Recommendation Report for Planning Permission for Works or Extension to a Dwelling

REF NO: P/121/21/HH

LOCATION: 80 Hook Lane
Pagham
PO21 3PE

PROPOSAL: Erection of a flat roof rear extension

Title			
Plans as Proposed Flat Roof			
Date	Drawn	Scale	Checked
July 2021	wm	1:100 @ A3	
Job Number	Prefix	Drawing Number	Revision
2021 38	P	04

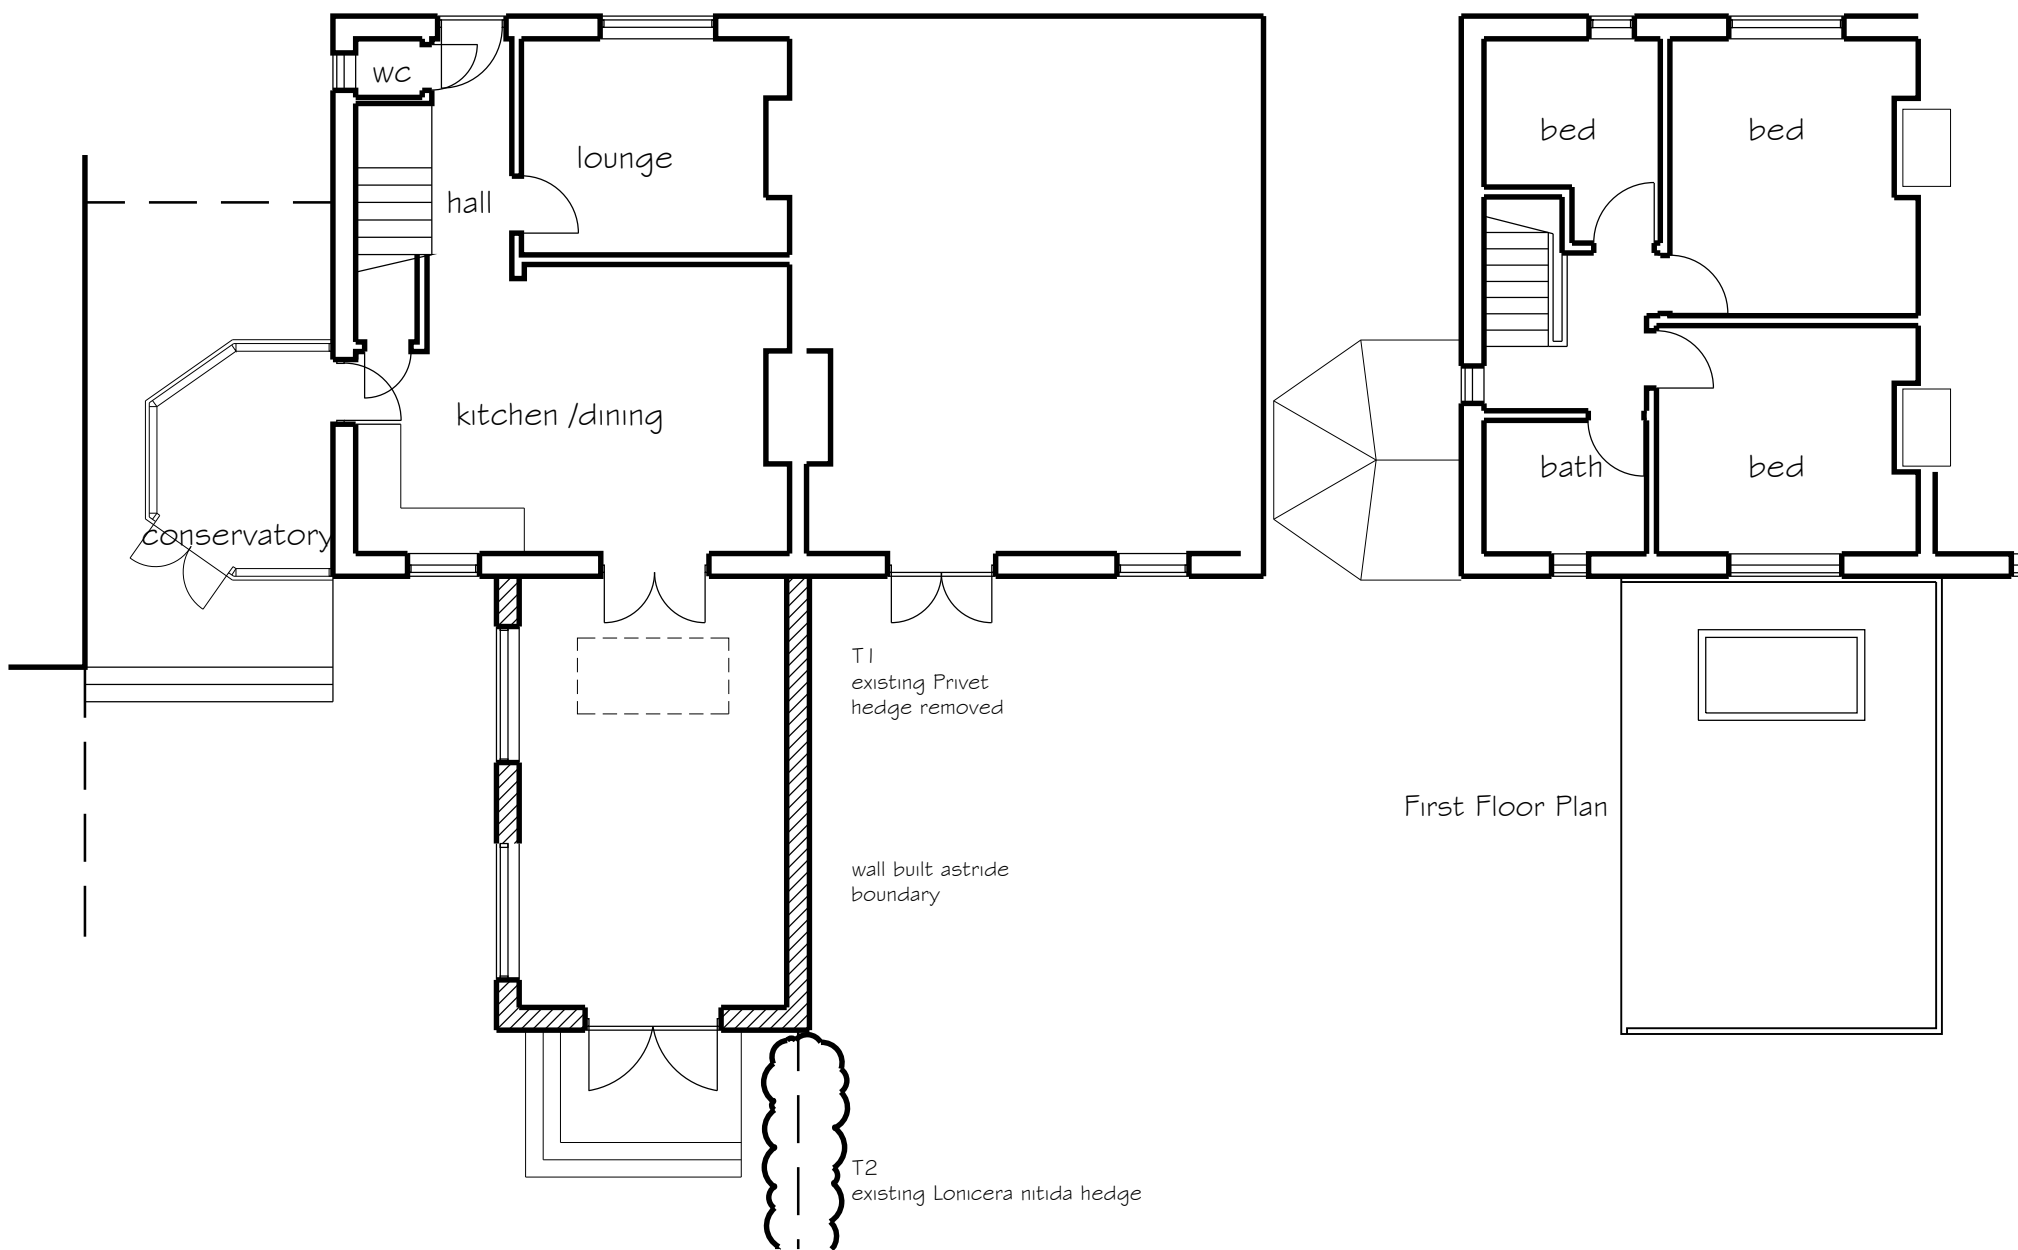
It is a large addition extending 6m beyond the rear elevation with a flat roof, running along approximately half of the rear elevation of the property. Due to the bulk it adds to the rear, it is not considered to sympathetically relate to the host dwelling in conflict with DDM4 (a). Materials will although match the host dwelling which improves its visual integration with the host dwelling.

The neighbouring property has no extension and as such the proposal extends some way beyond their rear elevation. The Council uses a 45 degree rule to assess serious effects on neighbouring properties. The extension will run along the north eastern boundary and due to its siting and depth will intersect a 45 degree angle when drawn from the closest window to the boundary at the neighbouring property at No 10 Hook Lane Close. However whilst large, it is not considered a refusal is justified. This is because an extension could be constructed up to this depth under prior approval with no objections from the neighbours and with a support letter received from the neighbouring property, the development is considered acceptable.

Due to the siting of the extension, it is not deemed to result in impacts upon the property at No.78.

Title
Elevations as Proposed
Flat Roof

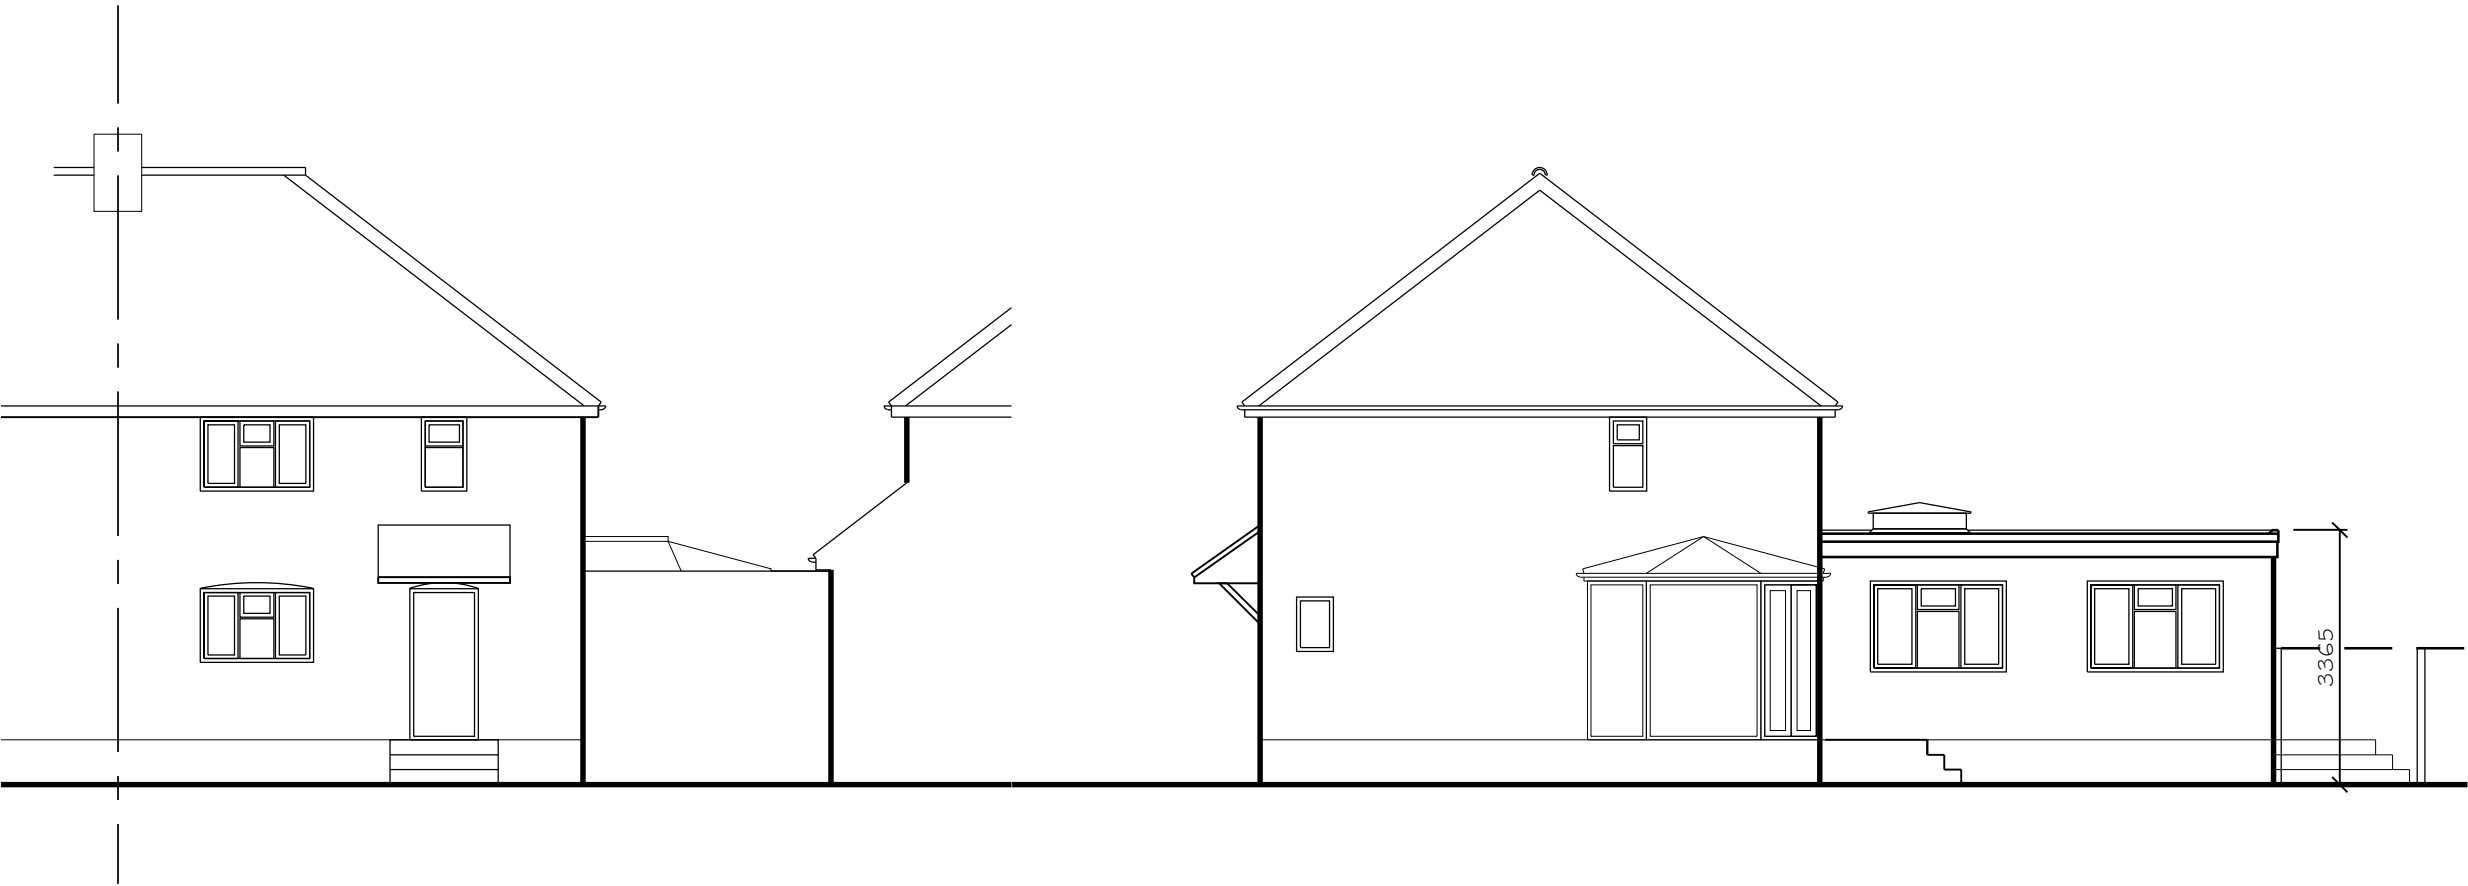
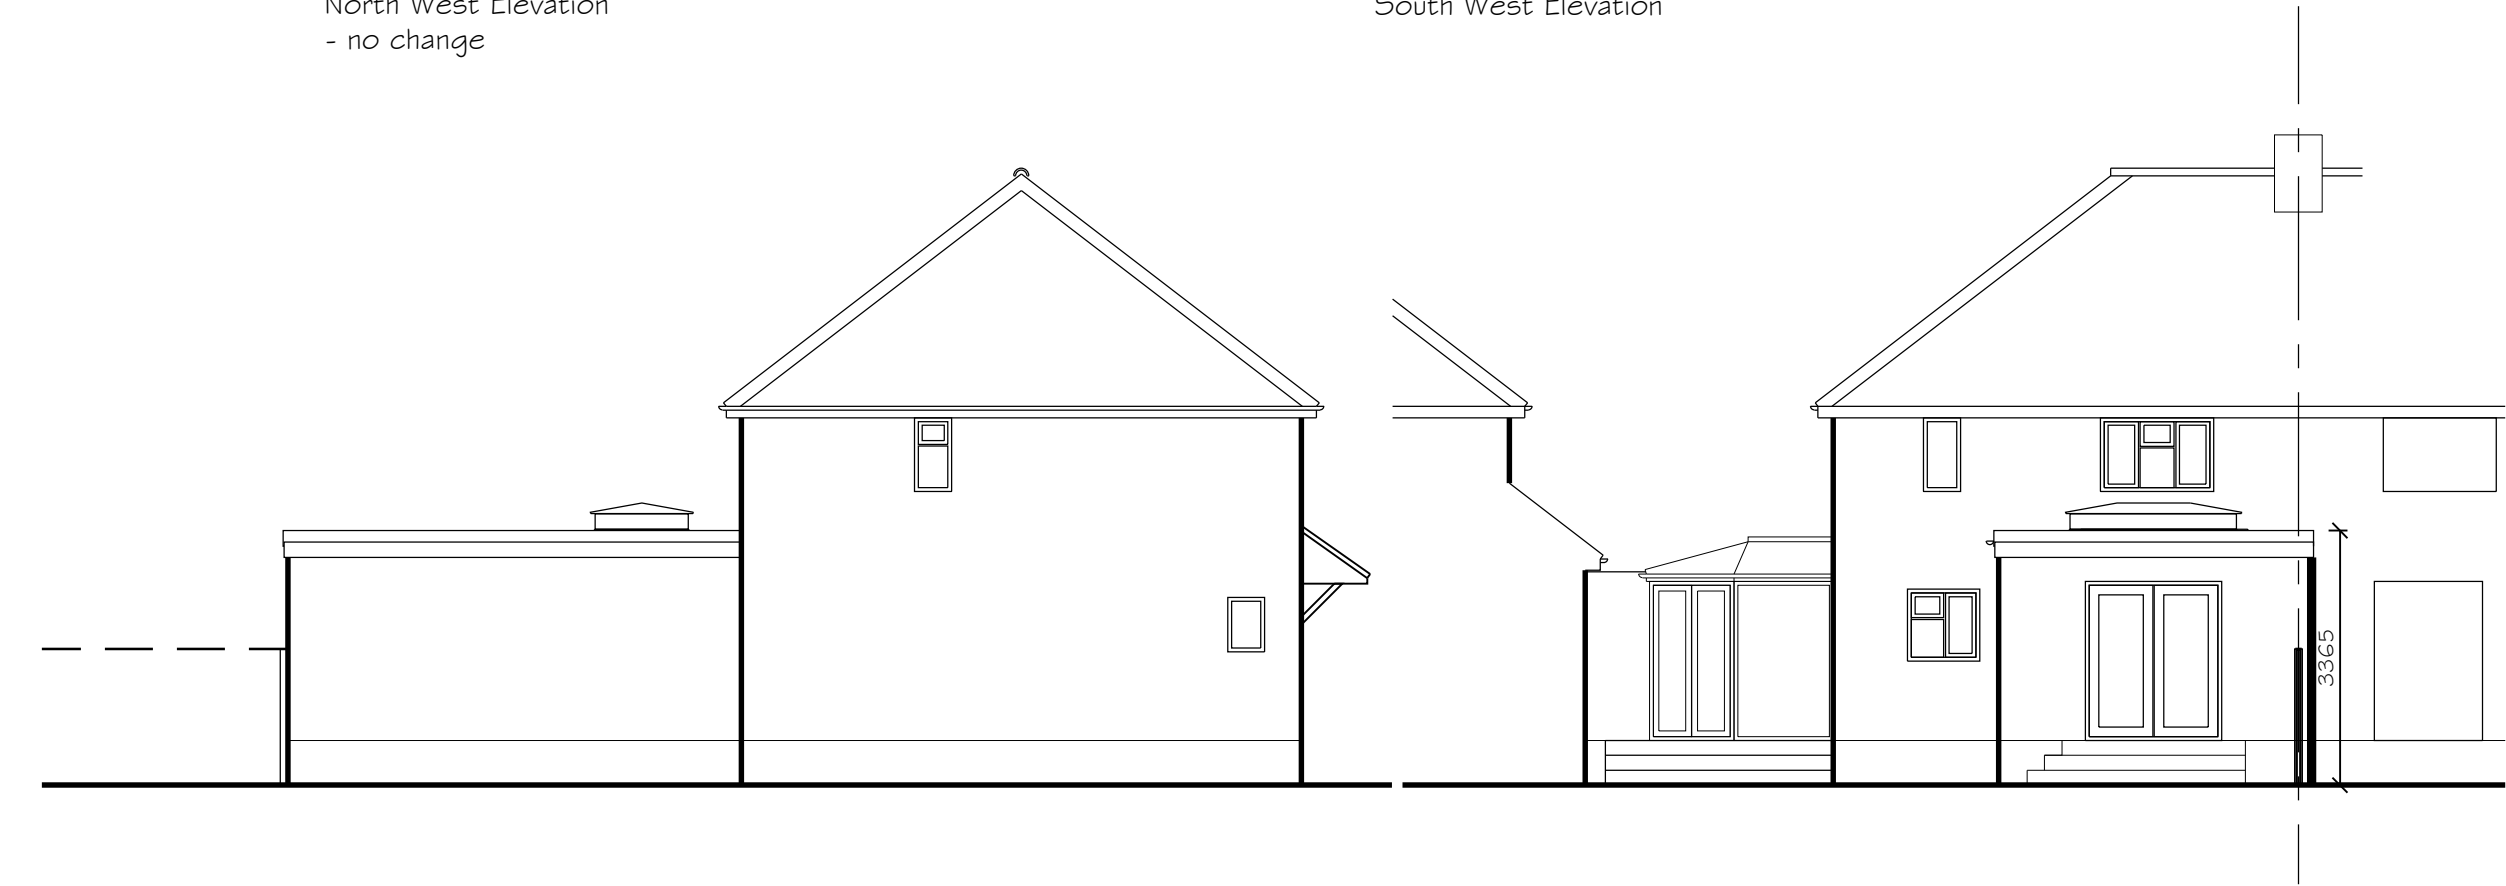
Section M of the Arun design guide states 'The scale, massing and positioning of extensions should be visually subservient to the existing property. Due to the size and bulk of the extension, it is not considered a subservient addition in conflict the Arun Design Guide and D DM4 (b) of the Arun Local Plan.

The extension will have a depth of 6m and a height of 3.36m.

The internal floor level is raised and there will be steps to a height of 0.5m which exit the extension, leading into the garden. With boundary treatment of 1.7m this will allow for views over the fence into the neighbouring garden. However this is not considered significant, with the steps leading into the garden, the use of the step at height would be minimal.

There will be 2 windows to the south west elevation and doors to the rear which will have views over the garden of the host dwelling.
